**SUBJECT: BRES2404-0027**  
**BUILDING RESIDENTIAL**

To: True Homes LLC

Here are the results of all Inspections located at **156 CAMEL CRAZIES PL:**

SHEET: S3

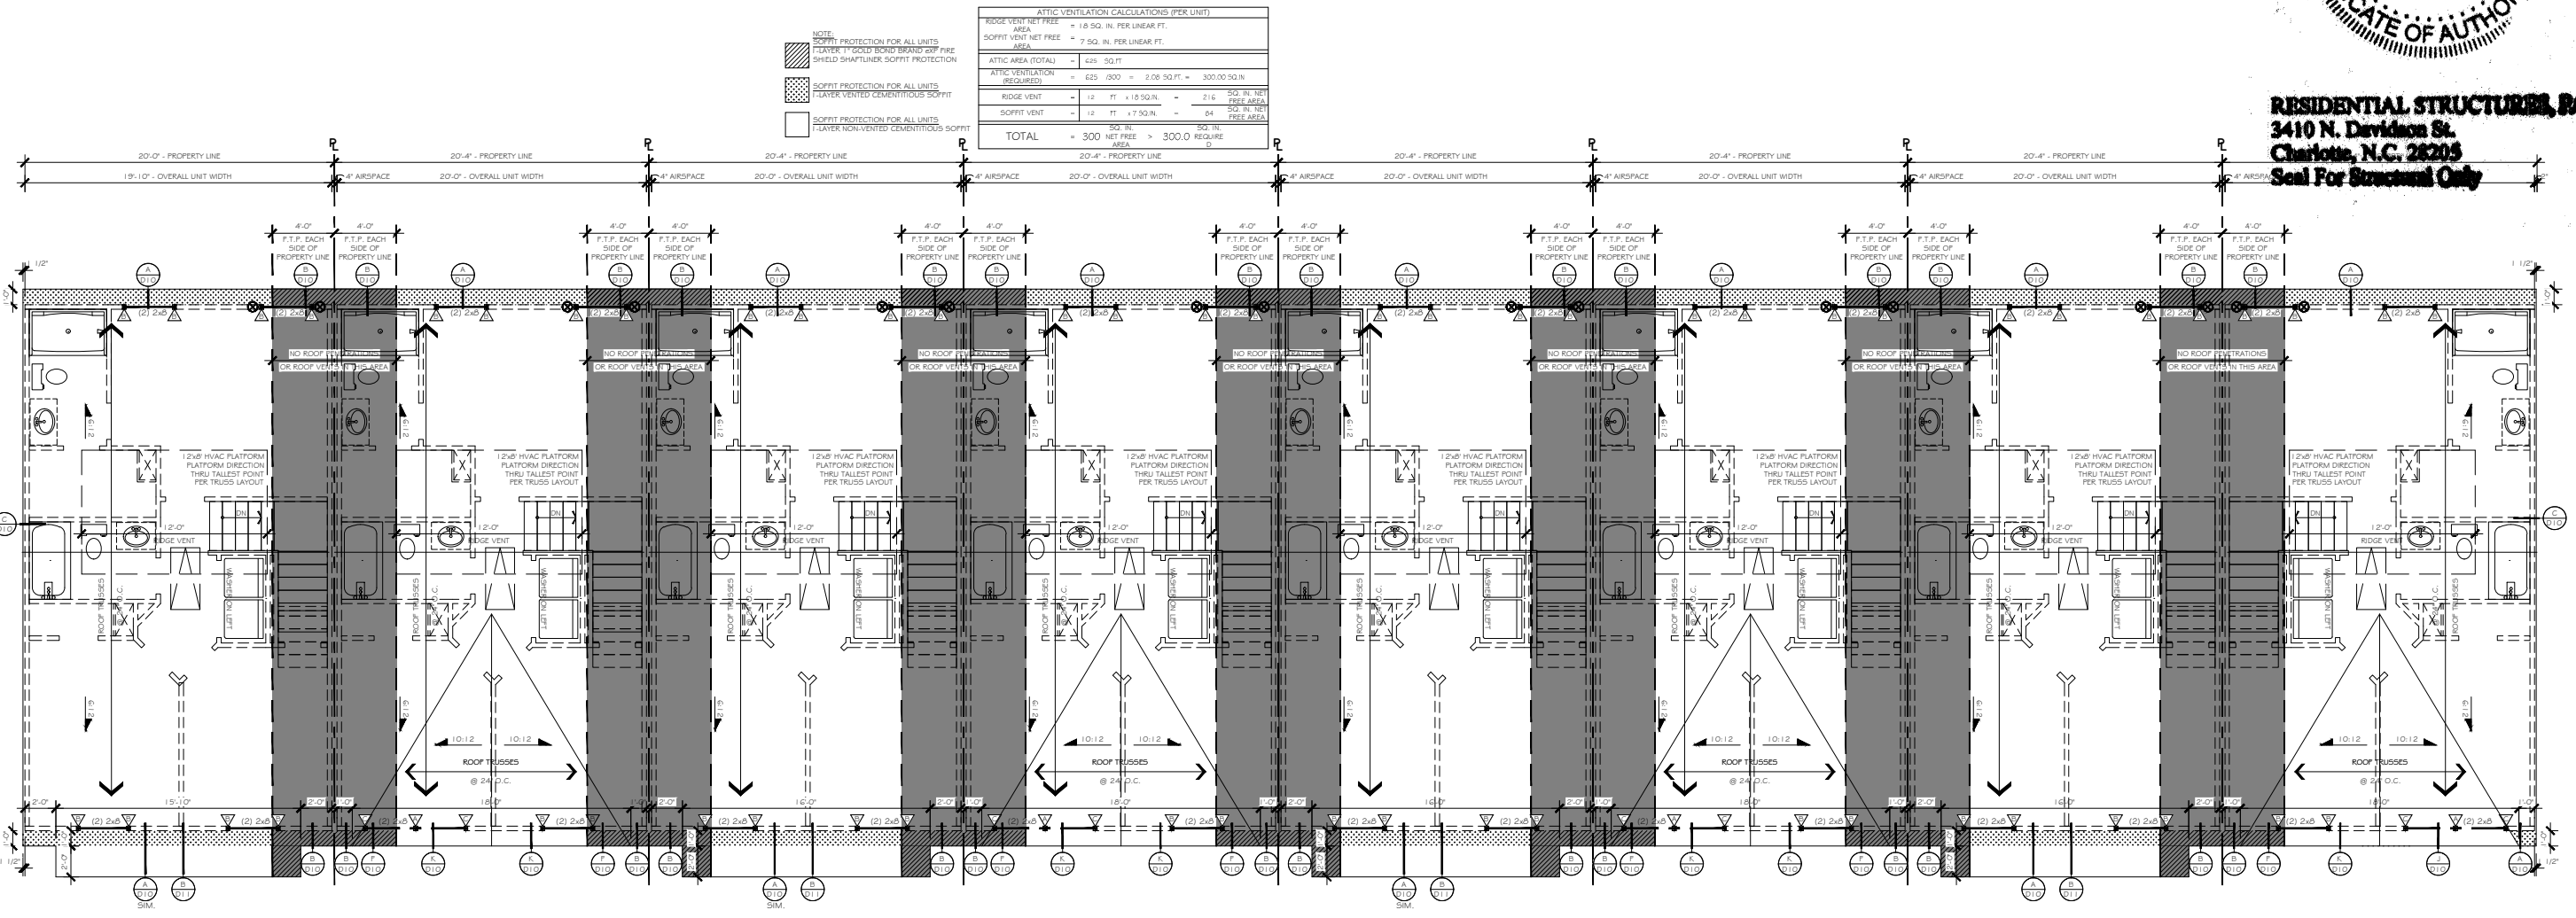
1. Missing kings on each side of front window header
2. Missing jack on right side of middle lvl
3. A3 missing top bracing
